PALMER SOLAR GEC PLAN

Grading and Erosion Control Plan_V1B.pdf Markup Summary

PPR-19-006

205

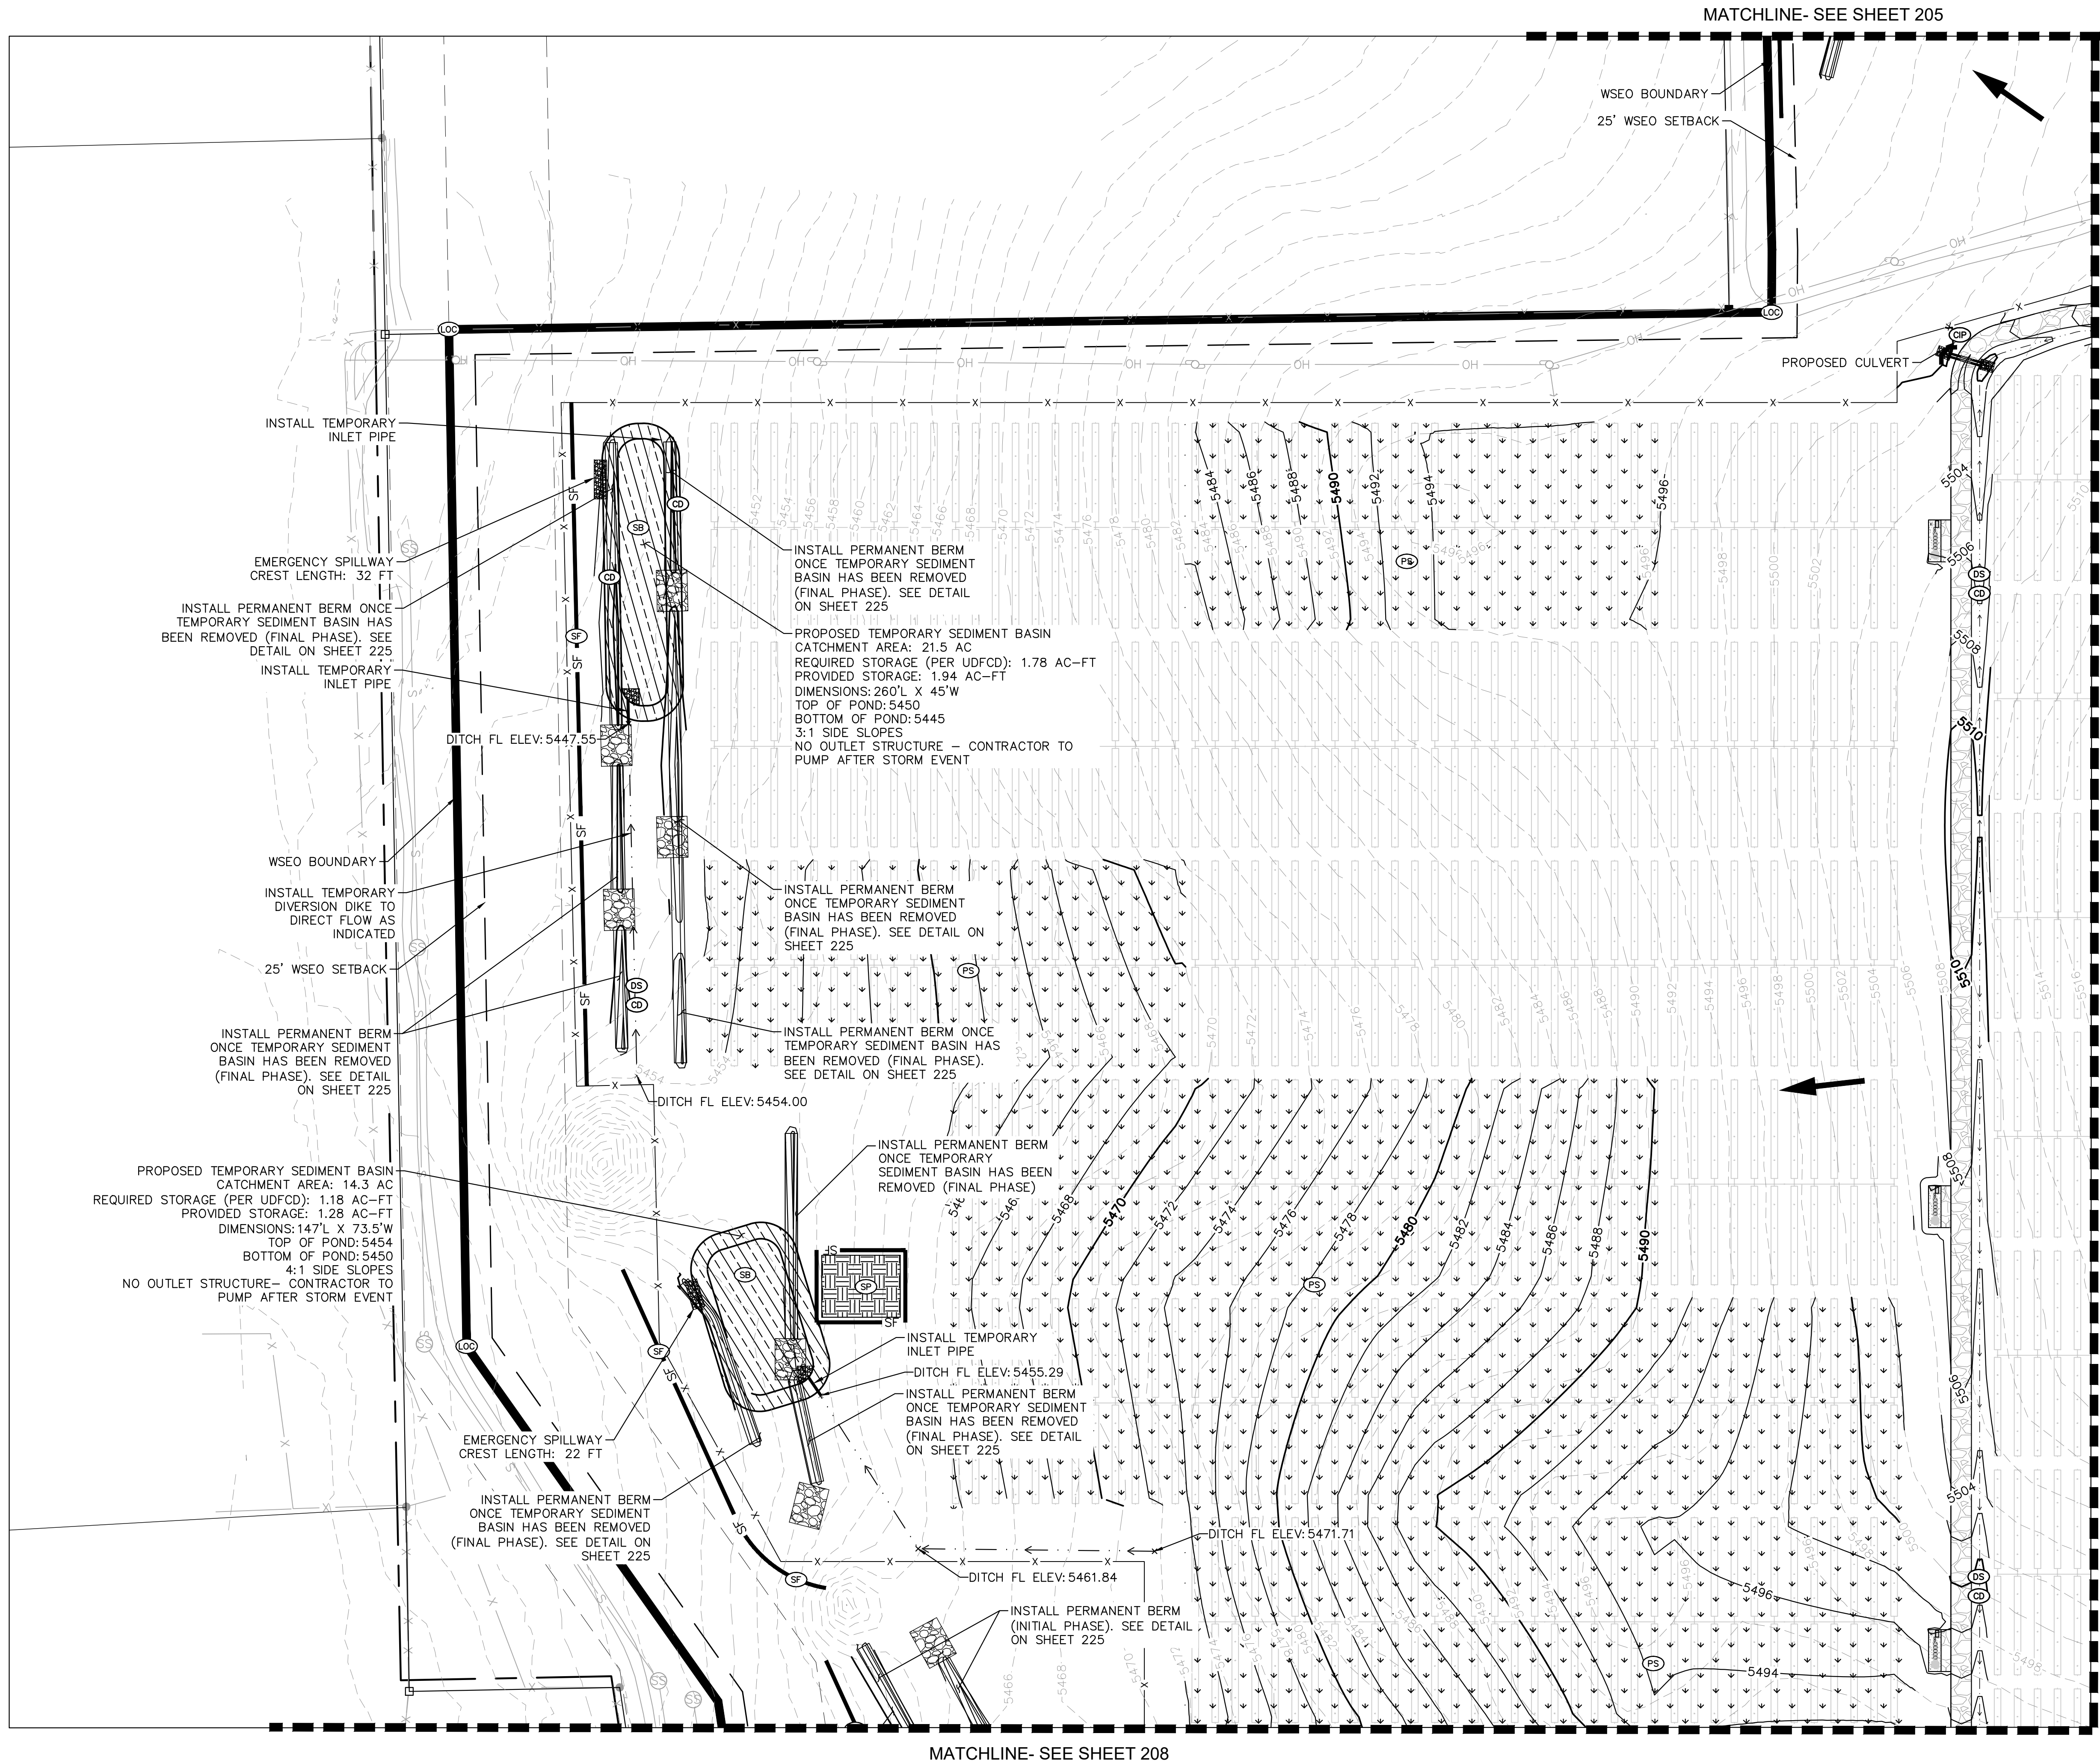
Subject: Highlight
Page Index: 6
Date: 3/3/2019 4:38:55 PM
Author: dsdrice
Color: ■
Layer:
Space:
Page Label: [6] 205 GRADING AND EROSION CONTROL PLAN

see comment letter
